**Subject: Ivilo Final Plat (SF245)**

The El Paso County Parks and Community Services Department has reviewed the development application for the Ivilo Final Plat. These preliminary comments are being provided on behalf of El Paso County Parks. This final plat application, along with the following comments and recommendation will be presented to the El Paso County Park Advisory Board for endorsement on February 14, 2024.

This is a request by SMH Consultants, Inc. on behalf of 6225 Vessey, LLC to subdivide the existing 6.15 acre property into two residential lots. The site is currently zoned RR-5, but an application to rezone to RR-2.5 has been submitted to the County. Approval of the minor subdivision would allow the property to be subdivided into 2 single-family residential lots.

Final Plat
VILO HEIGHTS SUBDIVISION

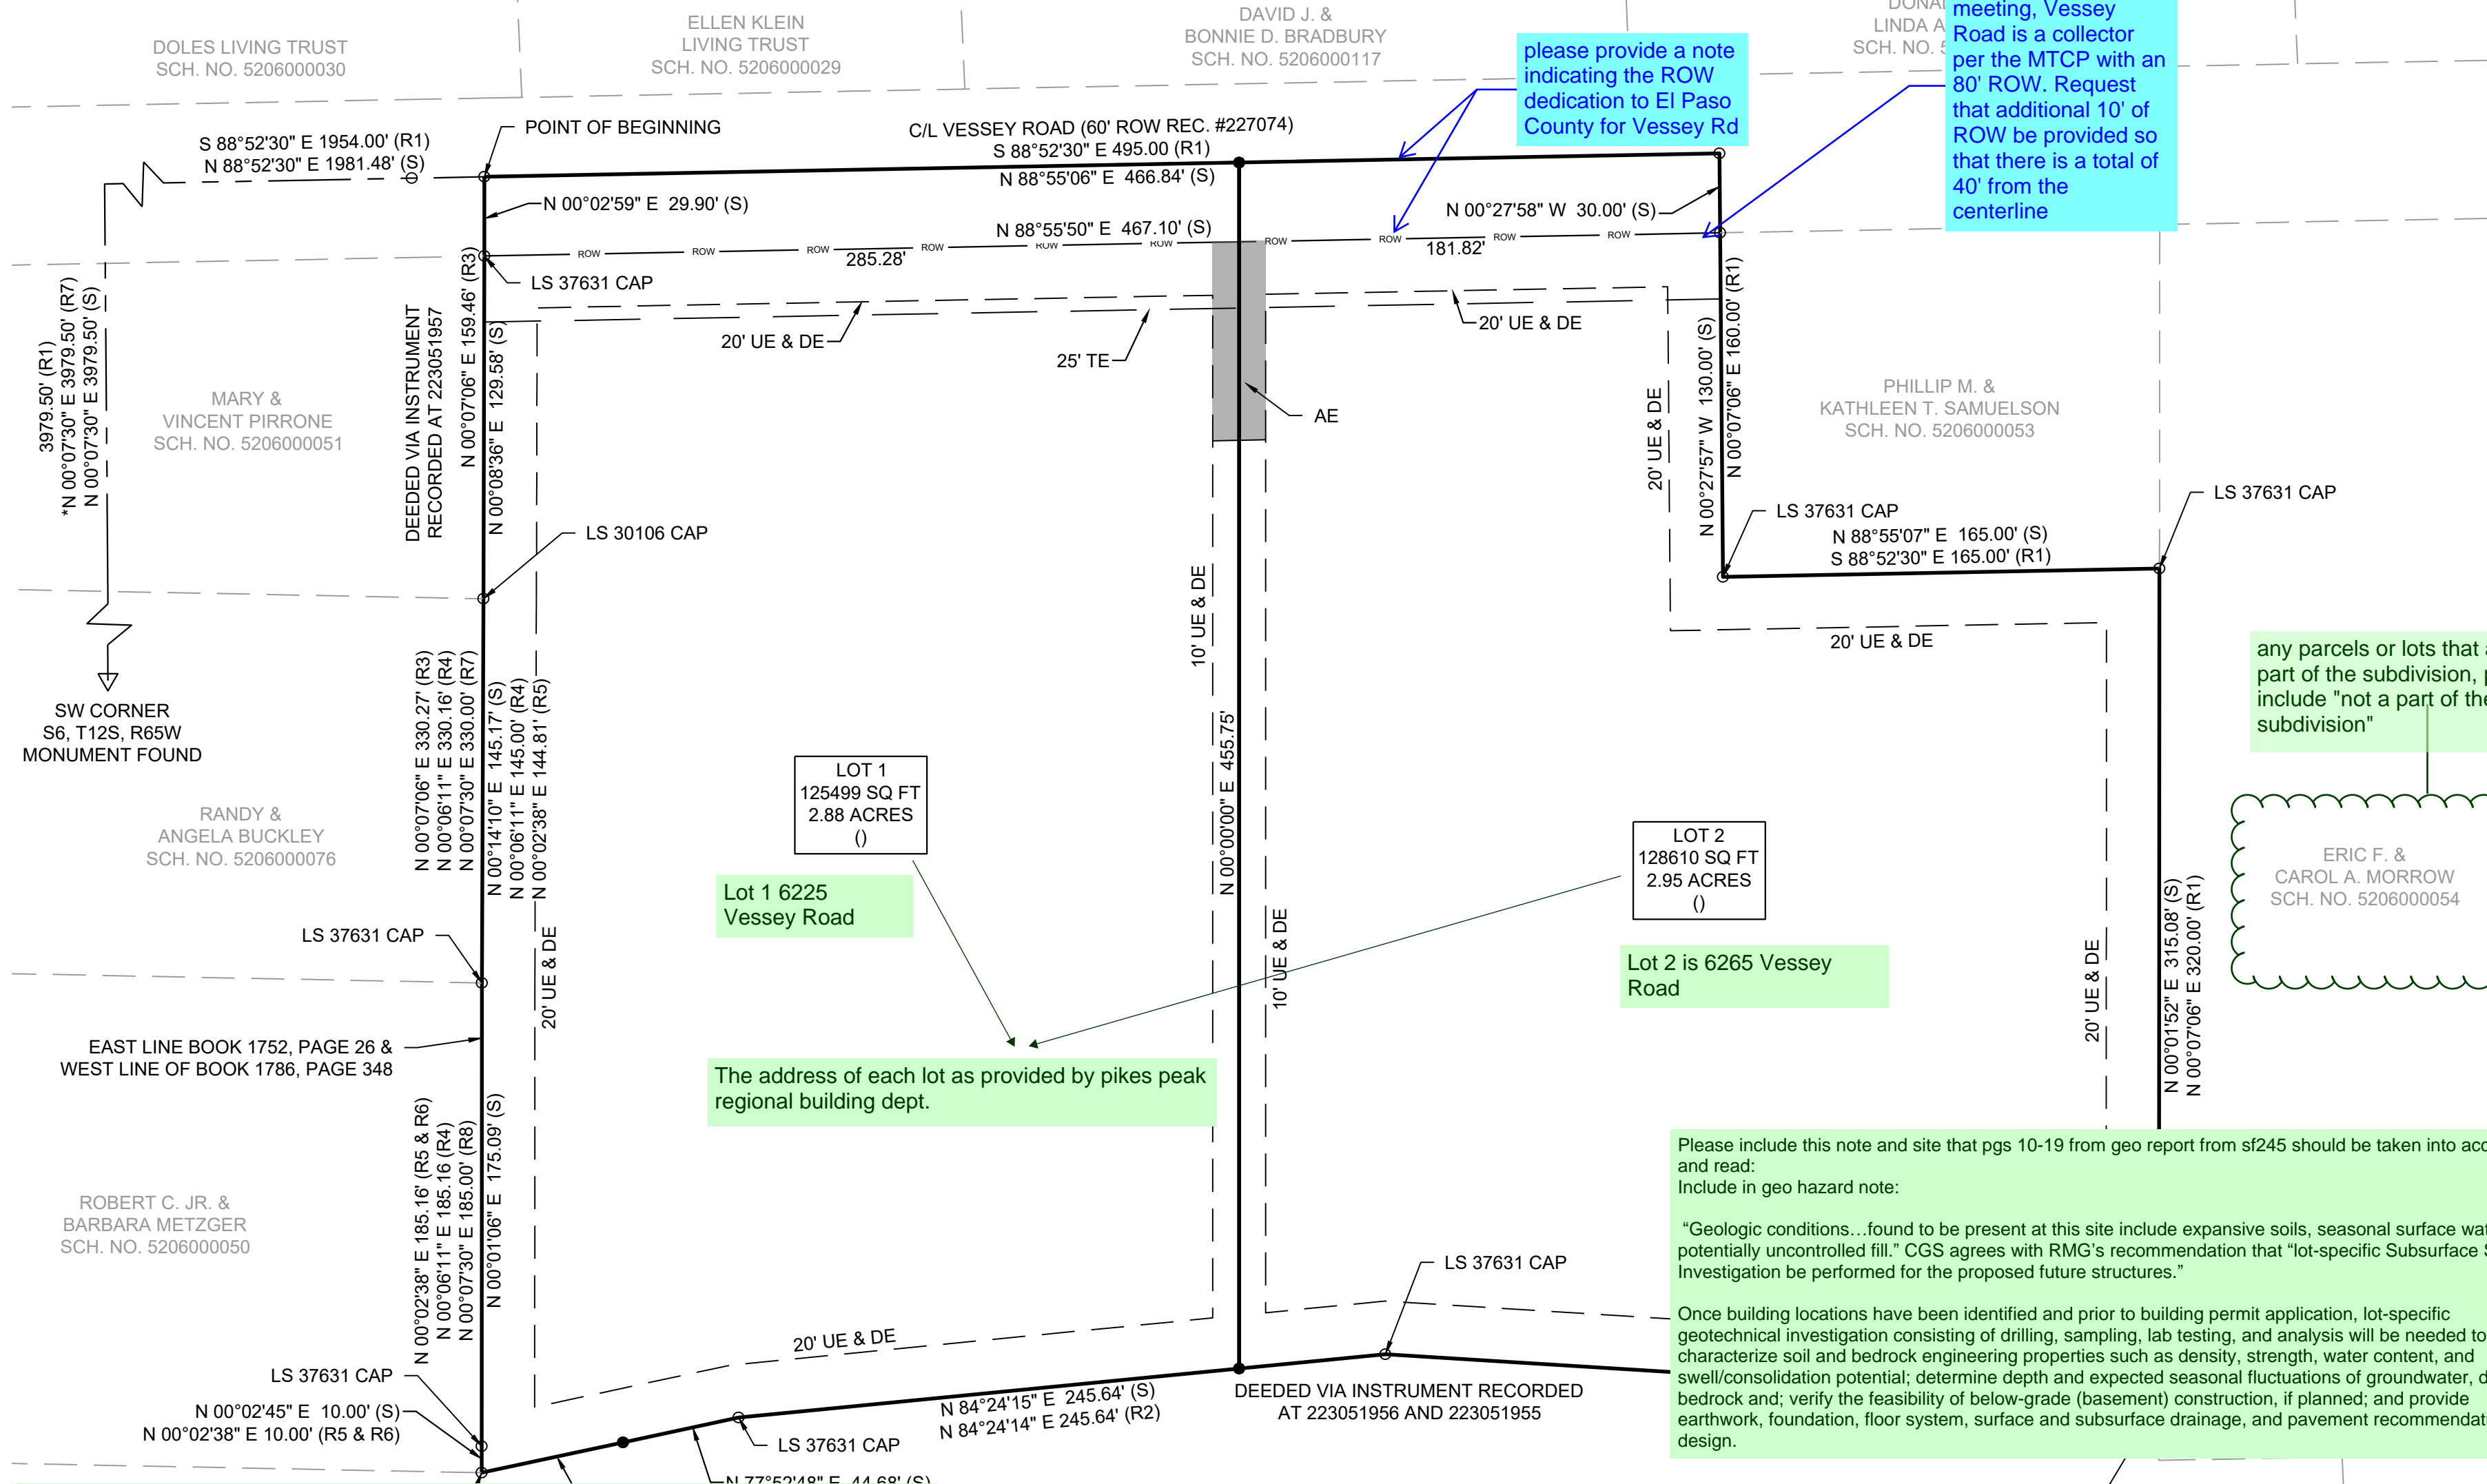
County Parks requests trail easements where development projects impact proposed County trails. As it pertains to the future minor subdivision application, the County will request that the landowner provide a 25-foot public trail easement along the north side of the proposed subdivision along Vessey Road to allow for the construction and maintenance by El Paso County of a the Palmer Divide Regional Trail, and this easement shall be shown and dedicated to El Paso County on the Final Plat.

*The Park Advisory Board recommends that the Planning Commission and the Board of County Commissioners include the following conditions when considering and/or approving Ivilo Final Plat: (1) require fees in lieu of land dedication for regional park purposes in the amount of \$1,010; (2) request that the landowner provide a 25-foot public trail easement along the north side of the proposed subdivision along Vessey Road to allow for the construction and maintenance by El Paso County of a the Palmer Divide Regional Trail, and this easement shall be shown and dedicated to El Paso County on the Final Plat.*
